Re: PA23-021 – White Barn Brown Bear Car Wash – Technical Review 1
8907 & 8915 Soper Hill Rd – APN(s): 00590700031903 / 00590700031902

After preliminary review of the above referenced proposal, the Planning Division has the following comment(s):

Job Number: **22681**  
Sheet: **4**  
C30.4

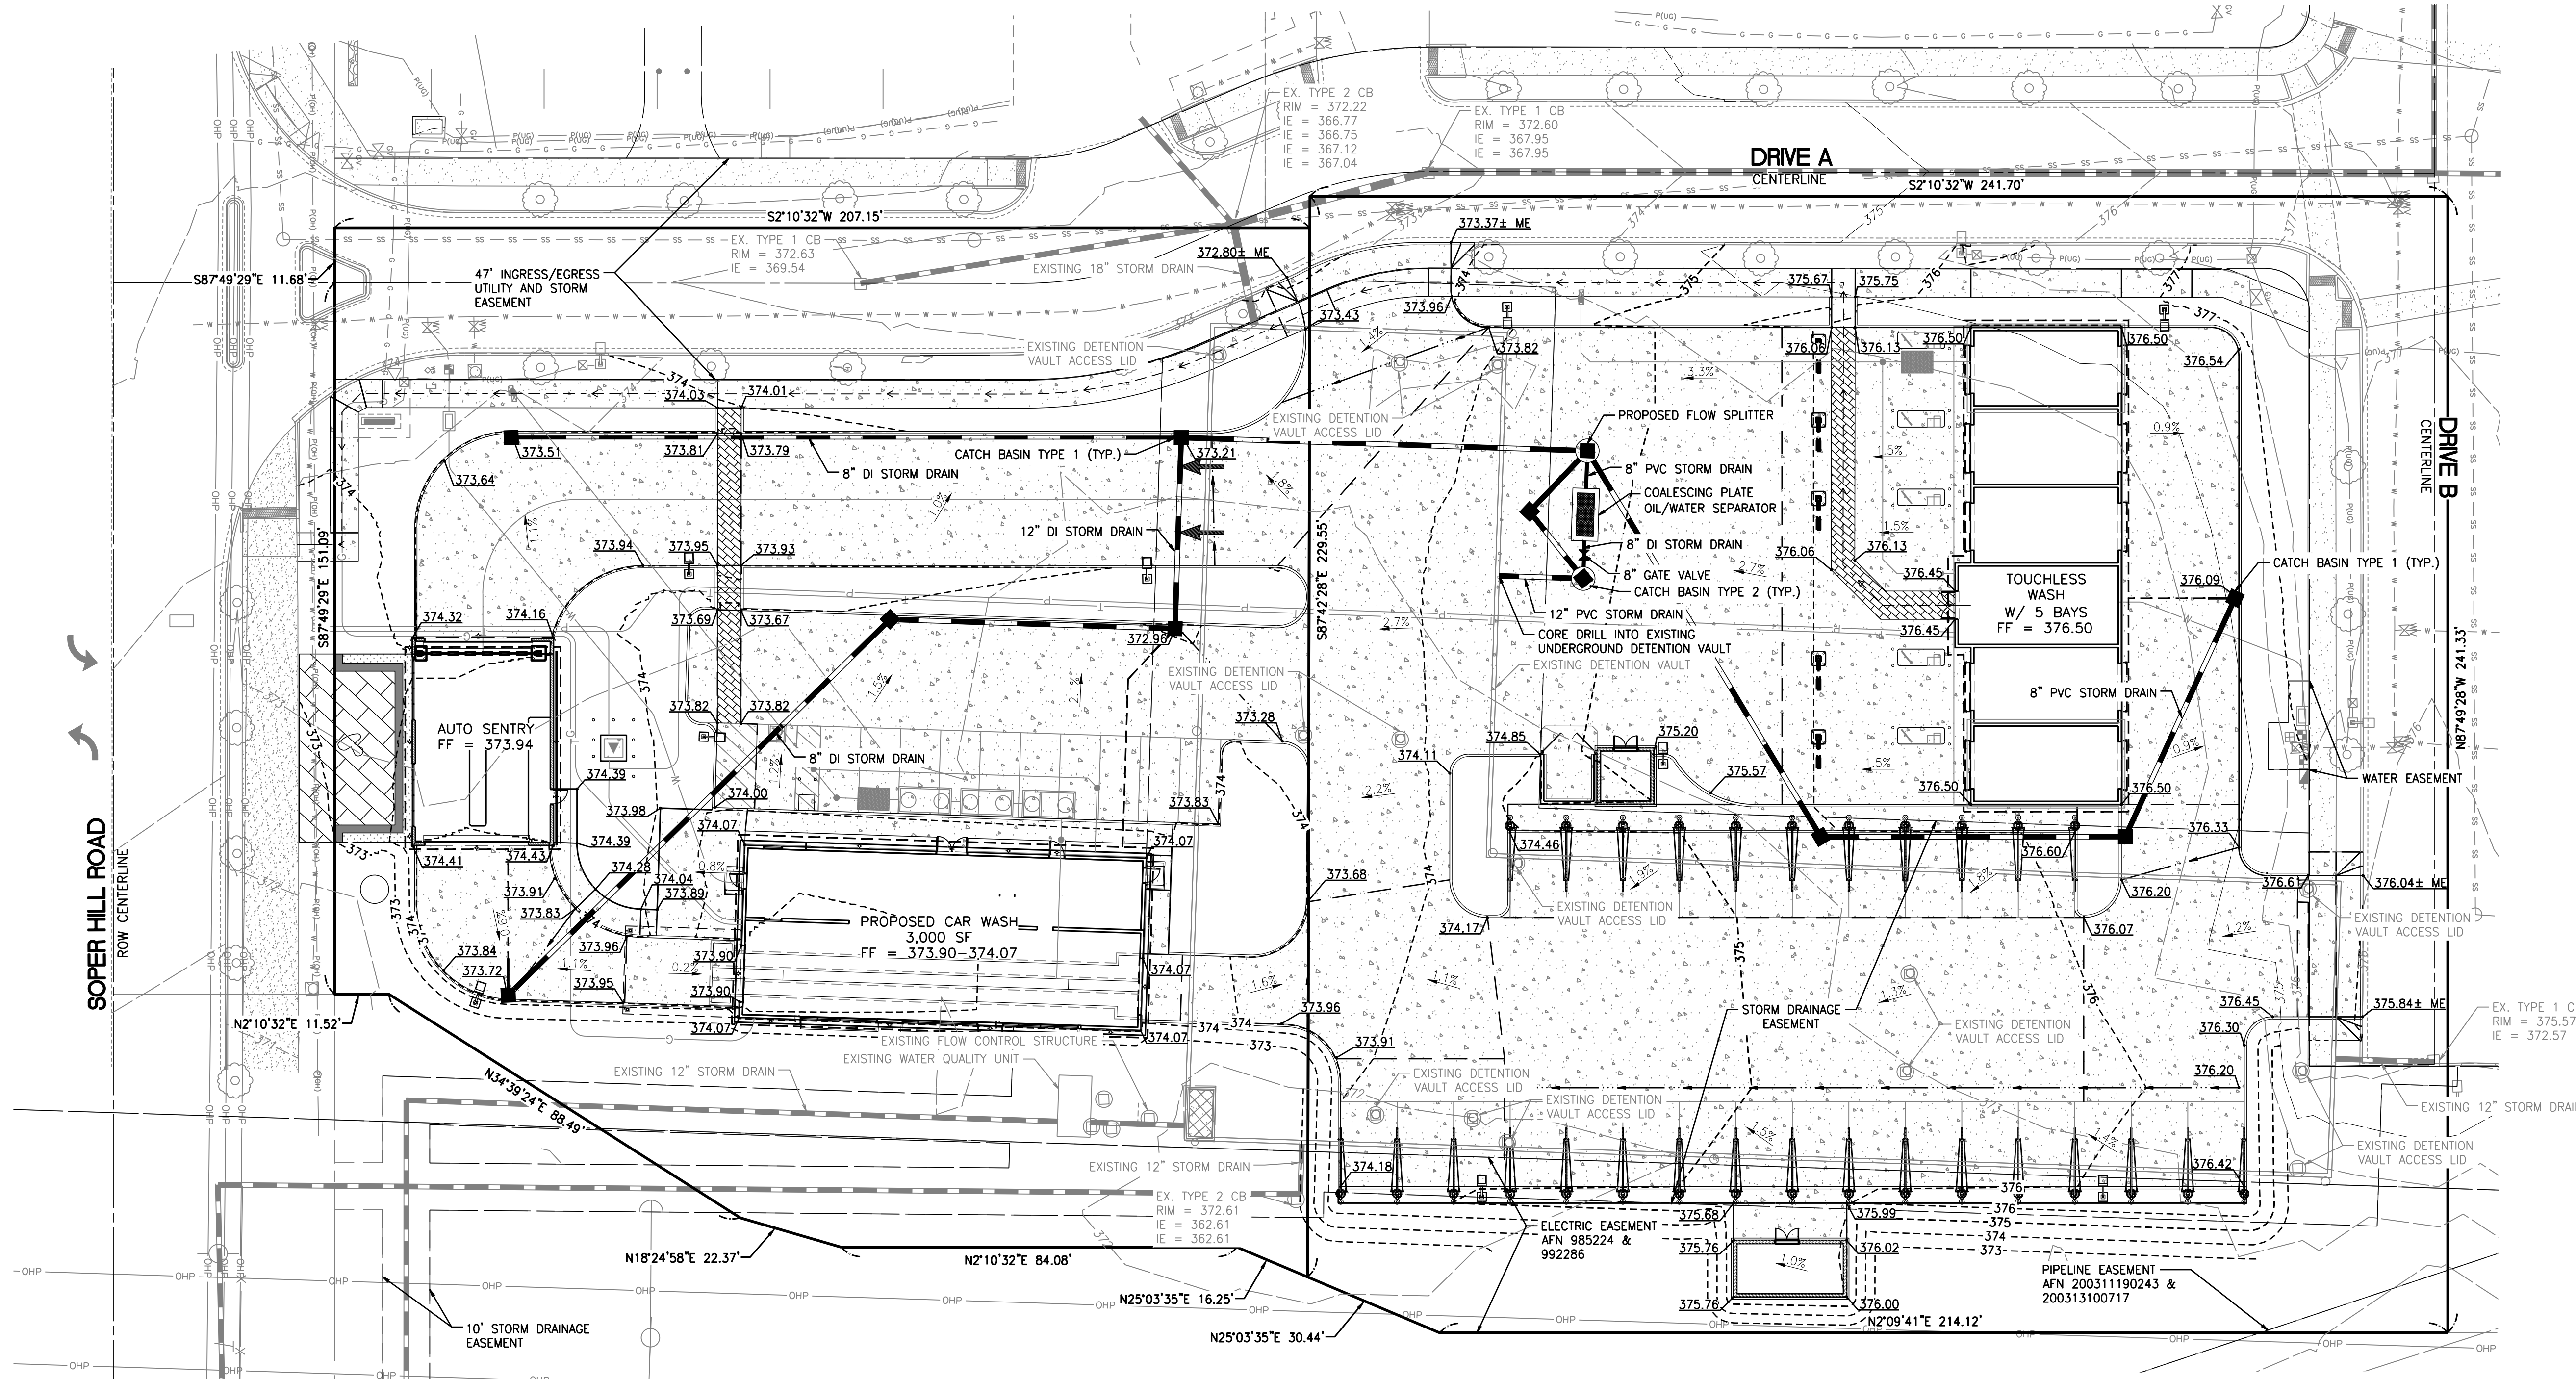
- b. No structures shall be located over the top of the stormwater vault. ***In addition, we're going to require that a structural engineer verify if the vehicle queuing over the top of the vault is within the design parameters of the lid.***

# PRELIMINARY LANDSCAPE PLAN

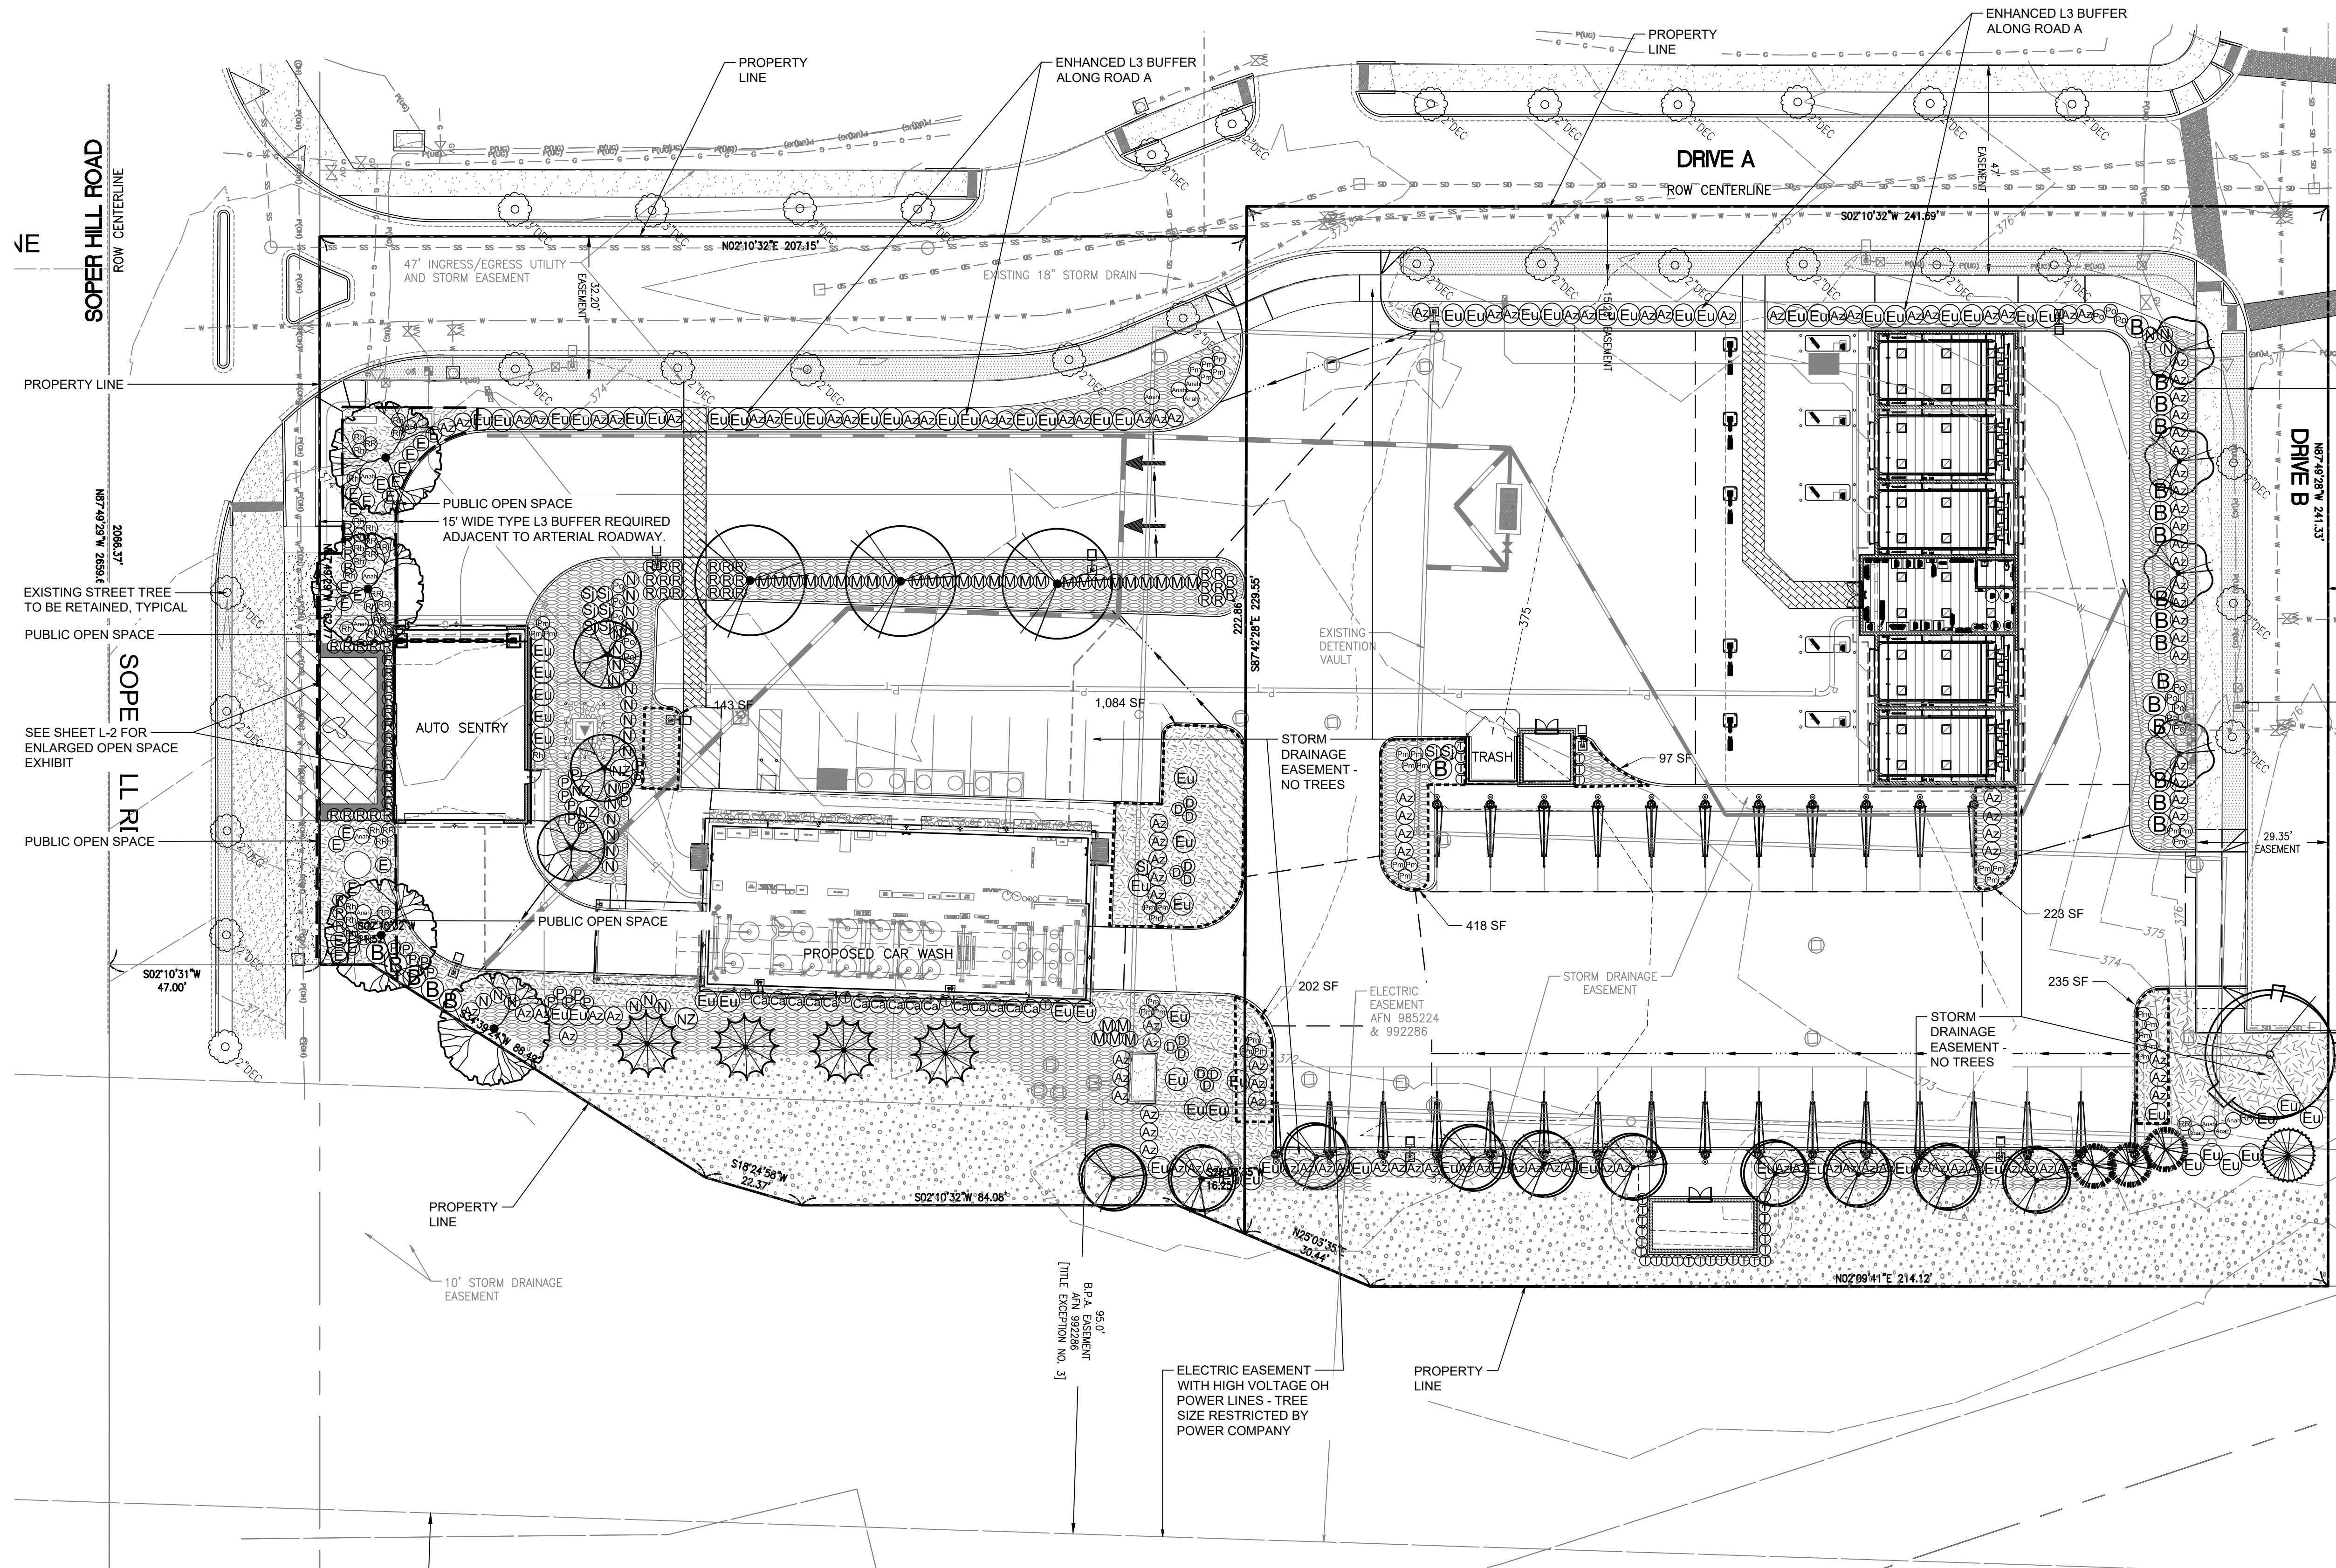
1. Pursuant to MMC 22C.070.210(2)(a)(ii), parking lots adjacent to internal roadways must provide a 20 ft. landscaped planting strip to provide screening and visual interest. Subsection (2)(a)(iv) does allow for the director to approve a reduced with planting strip so long as the intent of this section is satisfied. Being as the intent is to screen the vehicle parking/queueing area, adequate screening is needed. As proposed, a less than 7 ft. wide planting strip of plants that do not appear to meet the L3 – Broken Screen landscape type criteria and would not meet this requirement.

Please revise buffer to better meet the intent of this section. Examples could include a decorative low wall made of stone or masonry that is used in conjunction with landscaping, and/or use of a landscaped trellis or architectural columns. For each method, it is important to maintain visibility at eye level (between three and eight feet above the ground) between the street into the parking lot for safety.

2. 10 ft. buffer of L3 landscaping is required along Drive A and Drive B. The provided landscape shows a L3 type landscaping strip, but the selection of plantings do not appear to meet the description of what L3 – Broken Screen landscape type requires and therefore, the plan does not appear to propose a buffer that would adequately meet the intent of this requirement.

- 2.1. L3 – Broken Screen is a screen composed of intermittent visual obstructions from the ground to a height of at least 20 feet. The broken screen is intended to create the impression of a separation of spaces without necessarily eliminating visual contact between the spaces. It may be composed of a wall, fence, landscaped earth berm, planted vegetation, or existing vegetation. Compliance of planted vegetative screens or natural vegetation will be judged on the basis of the average mature height and density of foliage of the subject species, or field observation of existing vegetation. The screen may contain deciduous plants. Suggested planting patterns which will achieve this standard are included in administrative guidelines prepared by the community development department.

3. Provide a typical elevation view of all required perimeter buffer landscape areas.
